Your ref:
Our ref: 21/02408/F
Please ask for: Miss Sandra Homcenko
Direct dial: 01553 616824
Direct fax: 01553 616652
E-mail: borough.planning@west-norfolk.gov.uk

Details: **Garage and Replacement infill Extension at Brieryfield Lady Drove Barroway Drove Downham Market Norfolk**

I have received a planning application as detailed above but cannot process it until I receive some more information:

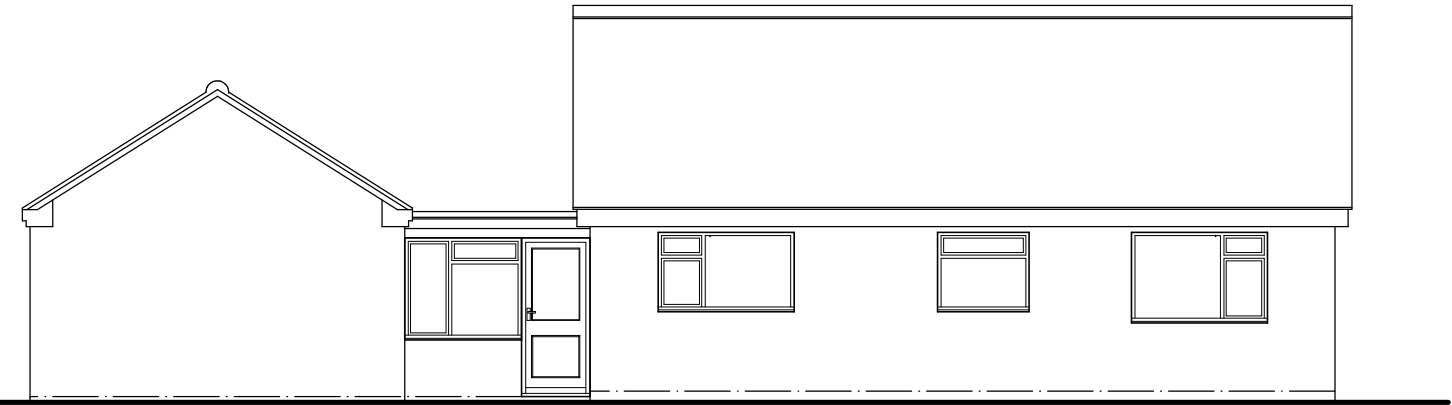
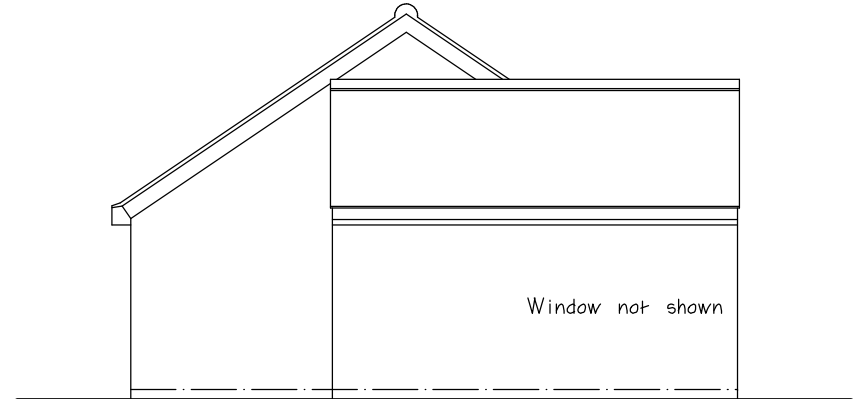
1. As the property lies within an area at risk to flooding, please complete the simplified Matrix and return it. The Matrix can be found at https://www.west-norfolk.gov.uk/info/20173/information_for_planning_agents/231/flood_risk_information
2. Please forward amended Existing plan showing window on NW Elevation
